**Application number:** 2024/0716

**Description:** Widening of existing drop kerb, widening of existing drive, and erection of new boundary wall and gates

**Location:** 110 Wood Walk, Wombwell, Barnsley, S73 0NE

Project.	110 WOODWALK WOMBWELL BARNSELY, S73-ONE		Client.		
Drawing Title.	PROPOSAL PLAN, ELEVATIONS, & SITE PLANS		Date.	JULY 2024	Scale. AS INDICATED
Ref.	105/81	Dwg. No.	02	Rev.	C

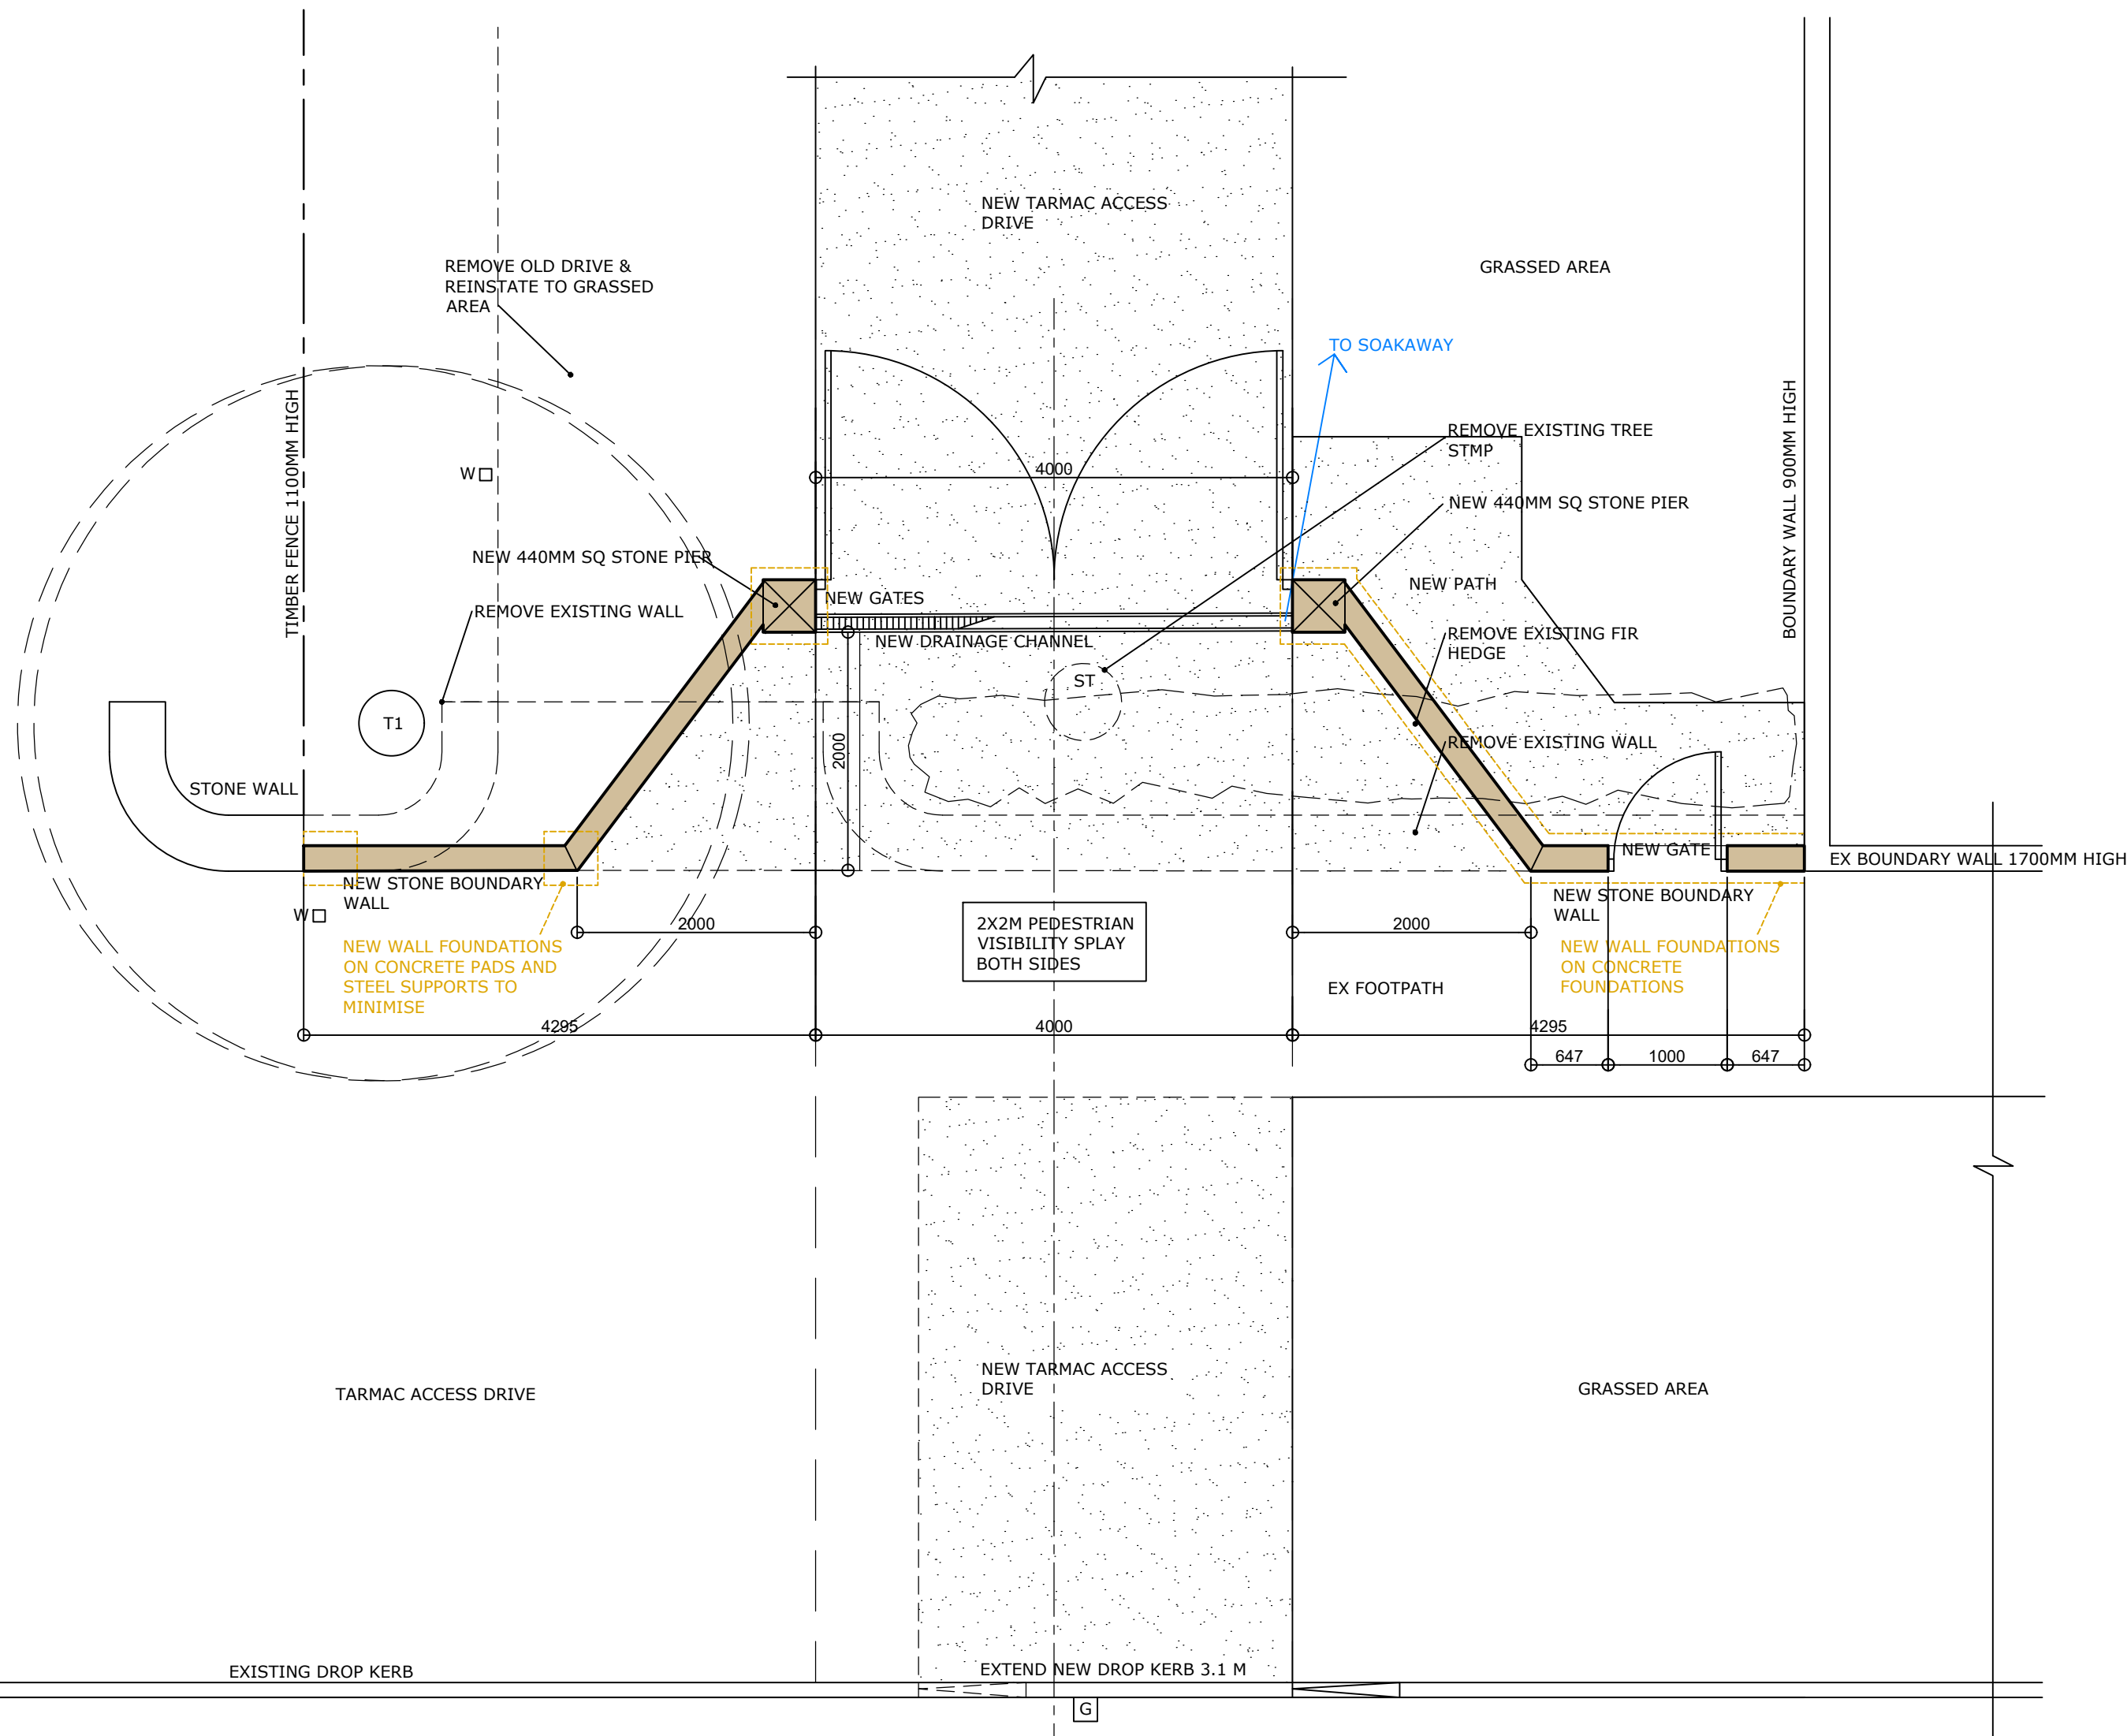
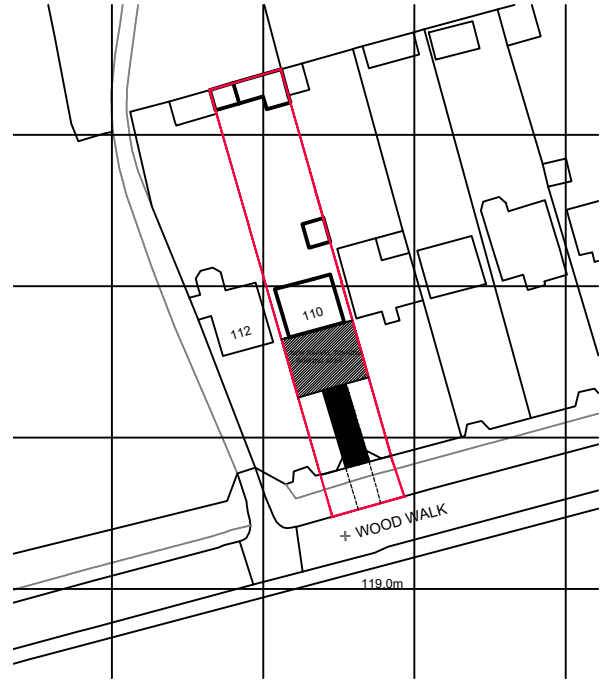
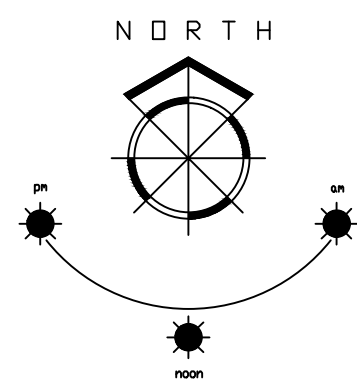
5.5. The applicant has stated that the wall would be constructed from natural stone with stone coping to top aluminium gates which would be finished in grey. Whilst the applicant has stated that the wall would be made from natural stone this information is lacking and is not very precise.

5.7. The construction of a 1.8m high boundary wall with 1.95m high Pillars and an aluminium gate finished in grey would be out of character with the surrounding area and would be contrary to the Walls and Fences SPD. In addition to this the proposed wall and columns would be higher than 108 Wood Walk as the boundary walls measure 1.7m high. Therefore, the proposed development would diminish the local character and negatively impact upon the visual amenity of the area.

- 6.1. In principle the LPA have no objections to the scheme, however the applicant has not proposed a development which is in keeping with the Walls and Fences SPD and the Local Plan. The design of the development would lead to the further diminishing of the local character due to the removal of the low Yorkshire Stone walls. Therefore, this proposal is recommended for refusal.
